KITTITAS COUNTY

TO: All Staff
FROM: Justin Turnbull, County Surveyor 
DATE: May 13, 2019
SUBJECT: County Survey Review of Final Plat LPF-19-0001 (Evergreen Ridge PUD – Rockberry Loop)
(3rd Review - Mylars)

EVERGREEN RIDGE P.U.D.-ROCKBERRY LOOP PLAT		
PREPARED FOR PATRICK DENEEN		
A PORTION OF THE NORTHWEST 1/4 OF SECTION 12, TOWNSHIP 20 NORTH, RANGE 14 EAST, W.M.		
KITTITAS COUNTY	WASHINGTON	
DWN BY D.L.P./G.W.	DATE 04/2019	JOB NO. 16078
CHKD BY D.L.P.	SCALE 1" = 200'	SHEET 1 OF 6

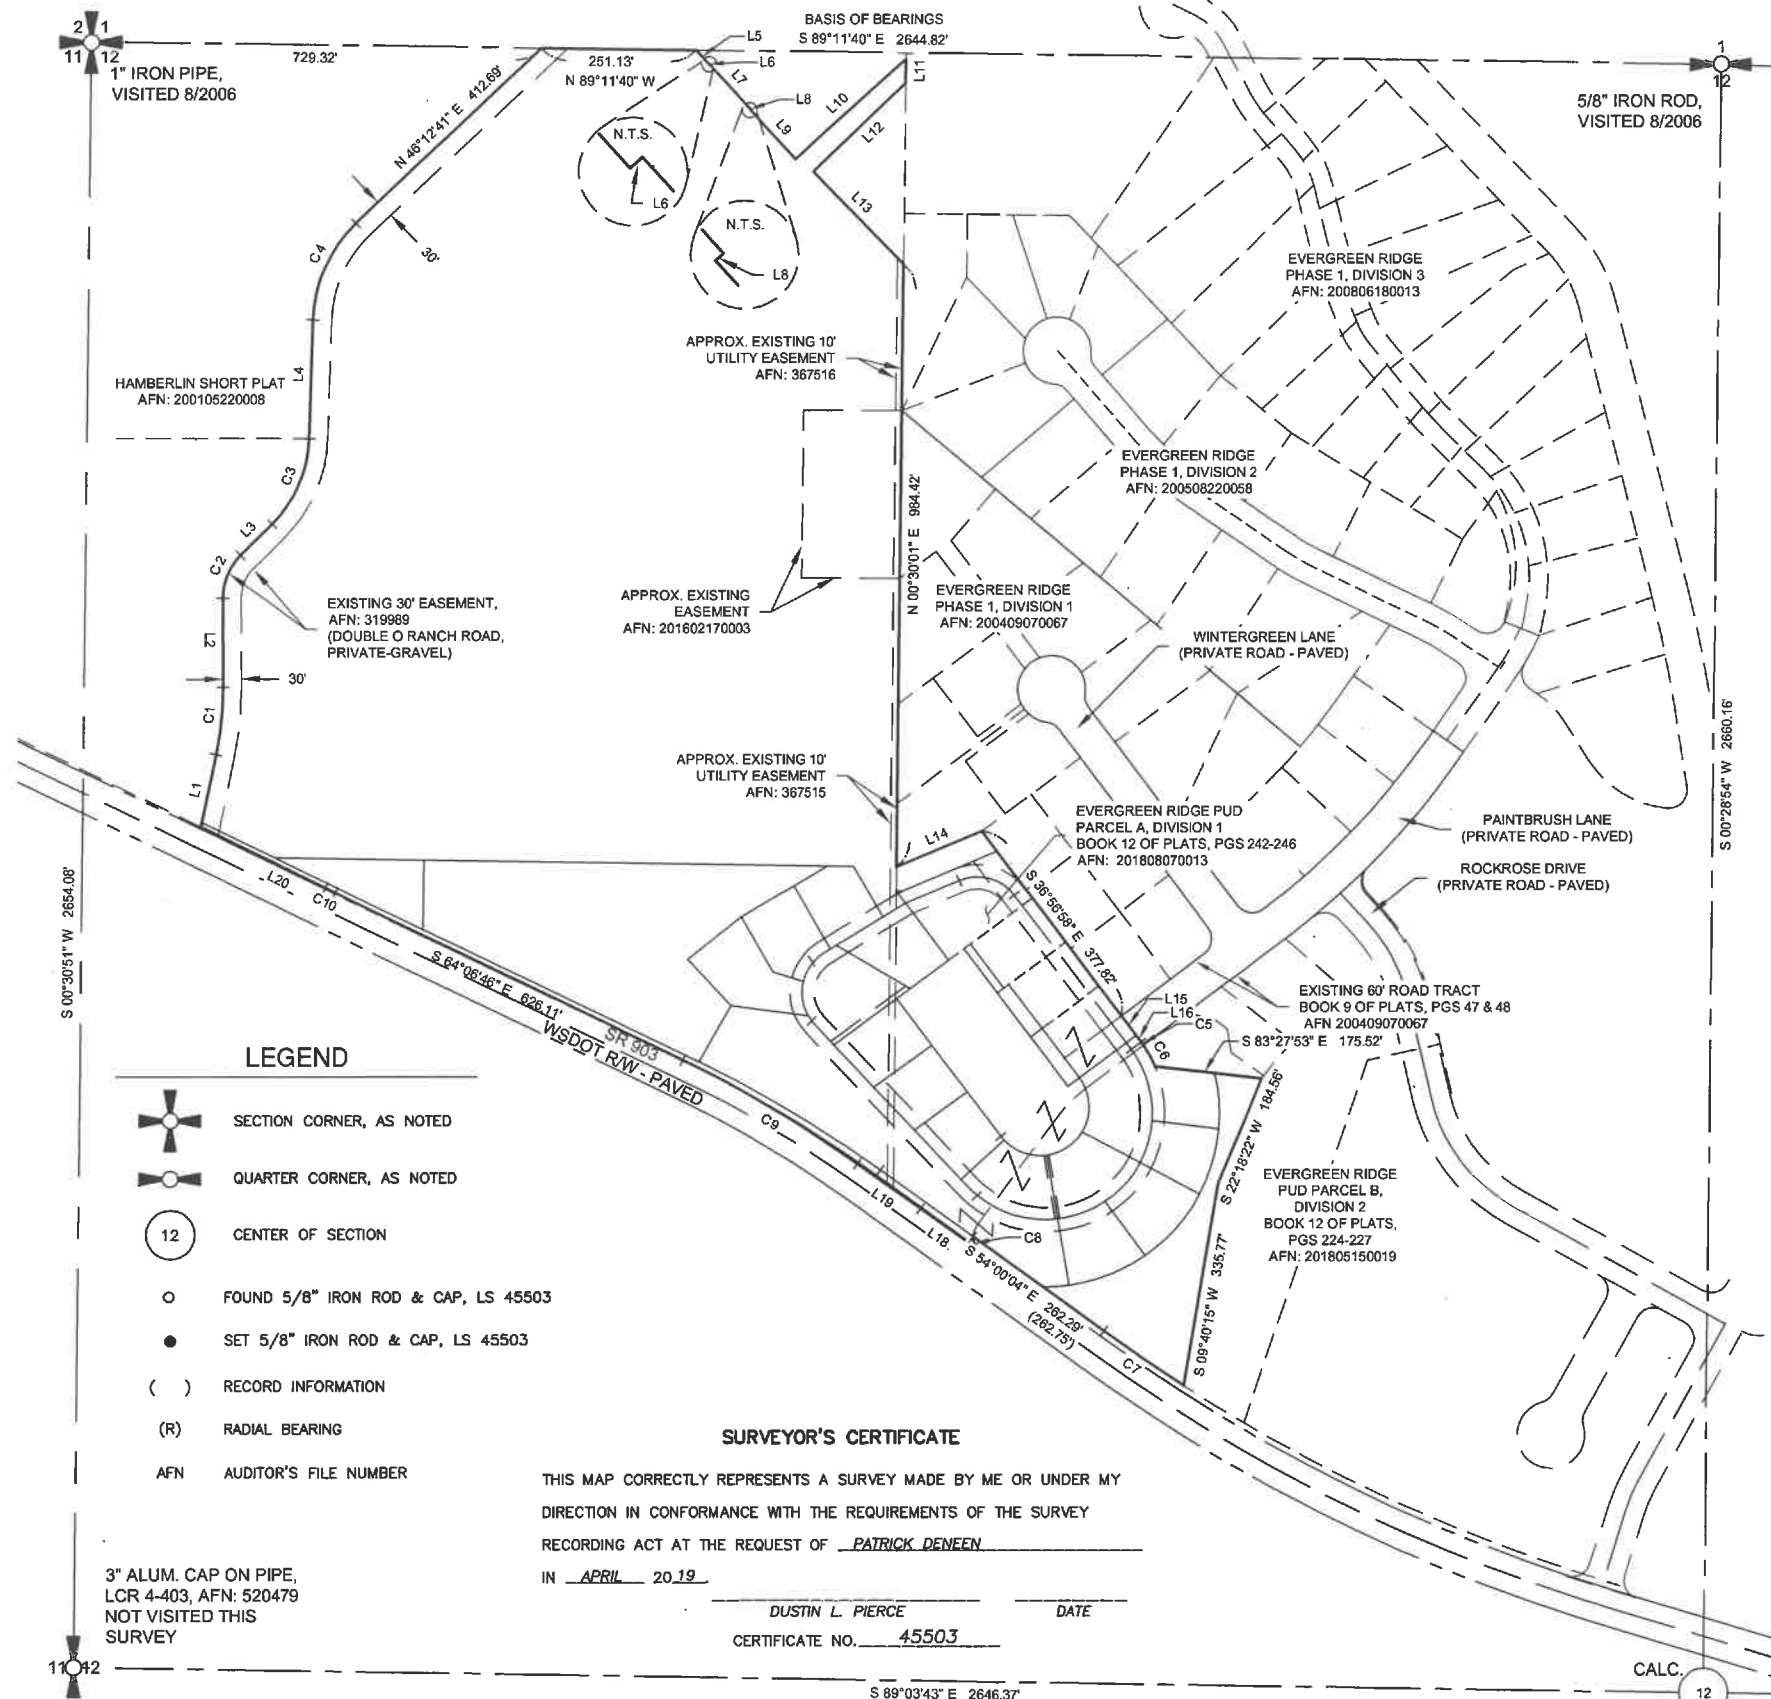
1. The following dimensions are obscured by adjacent text:

C8
20.04
23.95

While I am actually OK with this text being obscured as the data is clear on the subsequent page, DNR's recording office may raise issues.

DWN BY	DATE	JOB NO.
D.L.P./G.W.	04/2019	16078
CHKD BY	SCALE	SHEET
D.L.P.	1" = 100'	2 OF 6

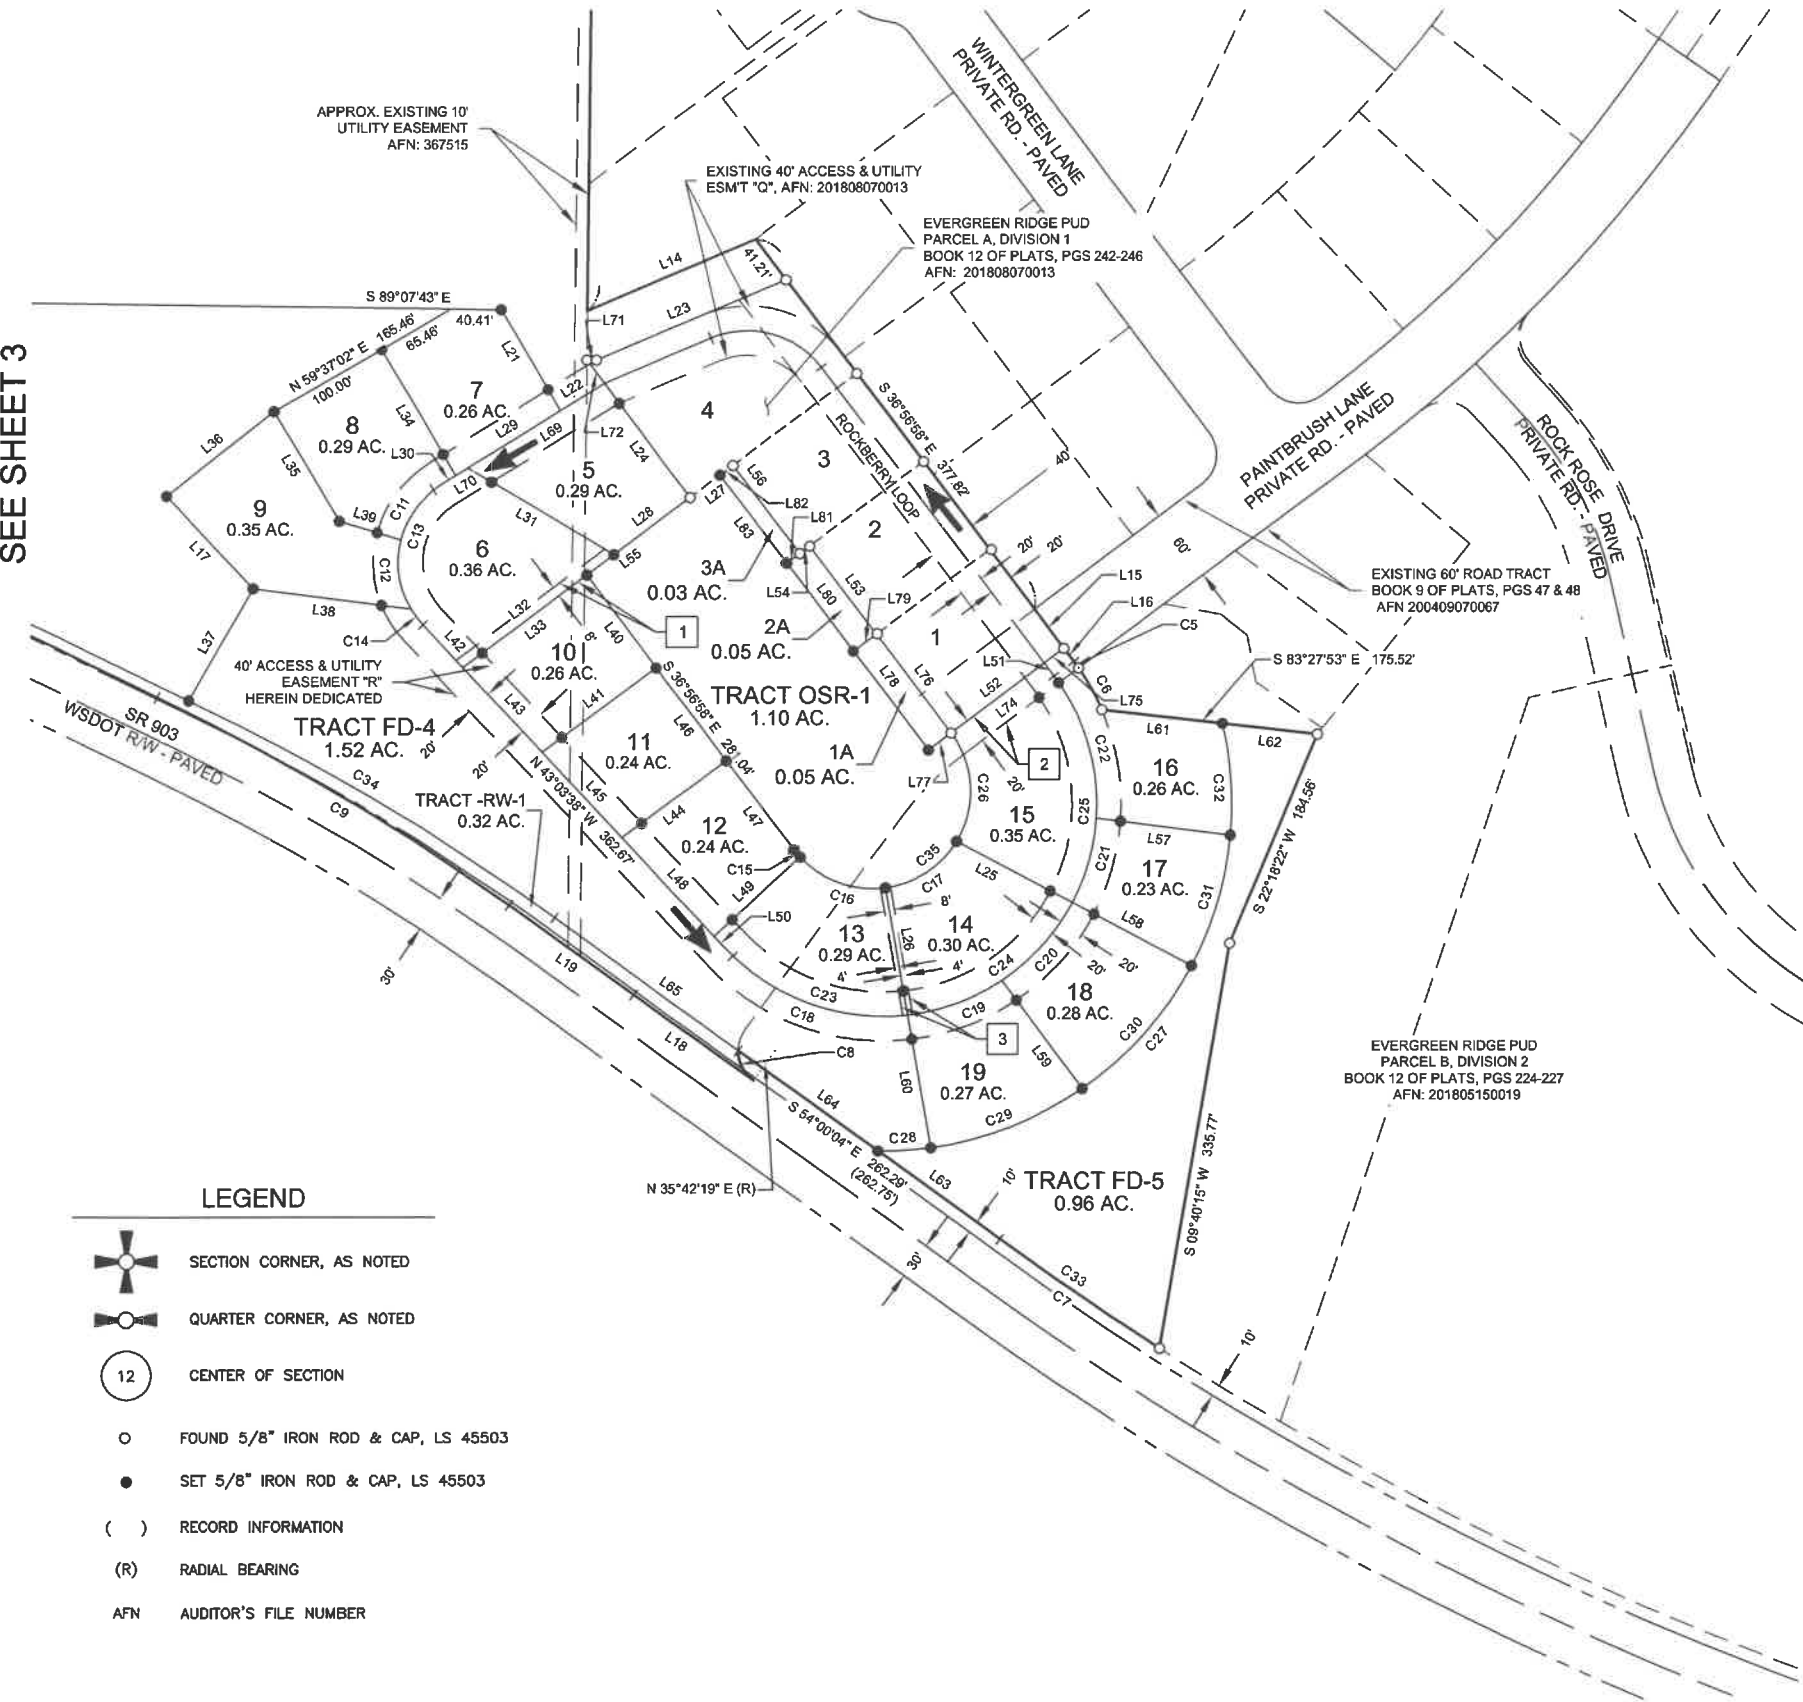
2. Dimension C24 is obscured.
3. The set corner on the North line of Lot 5, does not have any direct dimensions to it, as L24 and L72 measure to the center of Rockberry Loop.
